## *Rezoning Petition Review*

**Date of Review:** July 10, 2008 (**Revised August 20, 2008**)

**Rezoning Petition #:** 08-128

**Location of Property:** Approximately 2.50 acres located on the west side of Statesville Rd between Twin Lakes Parkway and Future I-485

Title: **SITE PLAN**

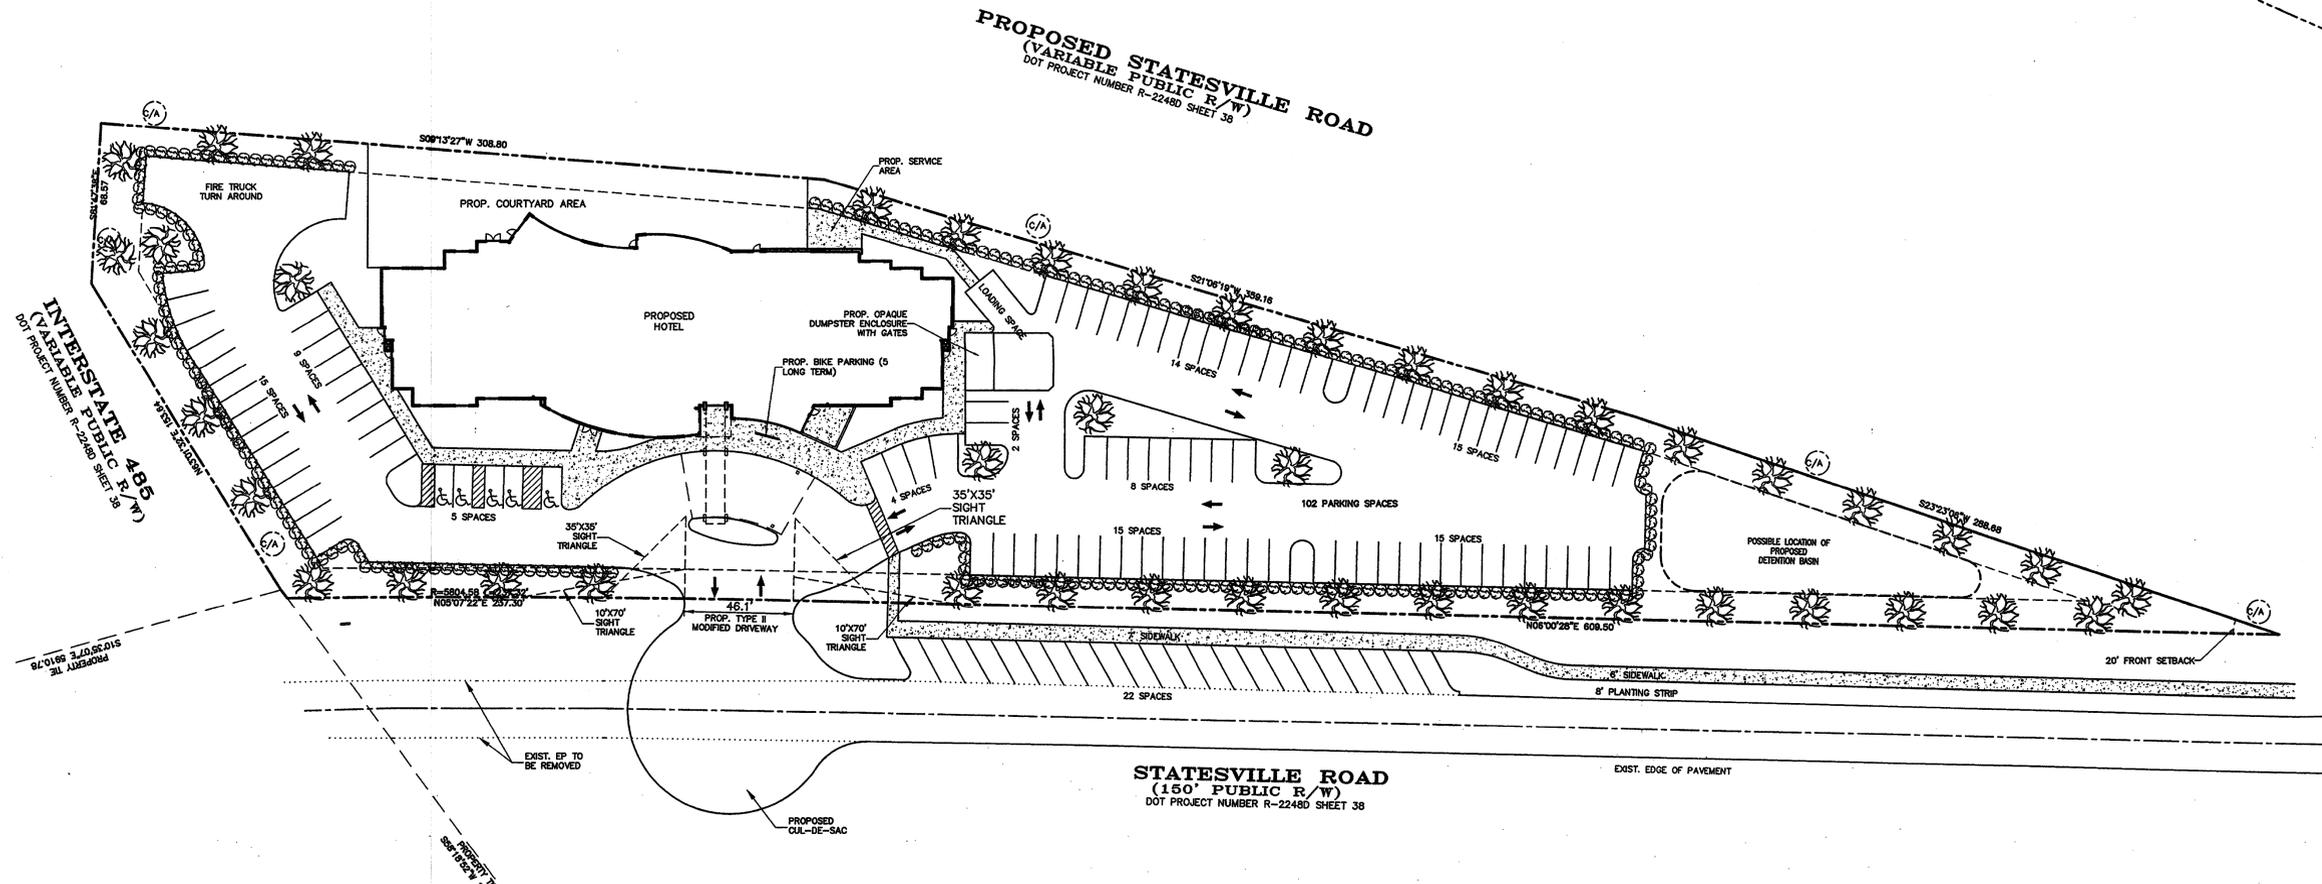
**Recommendations Concerning Storm Water:** **Please remove Notes 5, 6, 7 & 8 under General Provisions and replace with the following note**

The petitioner shall comply with the Charlotte City Council approved and adopted Post Construction Controls Ordinance.
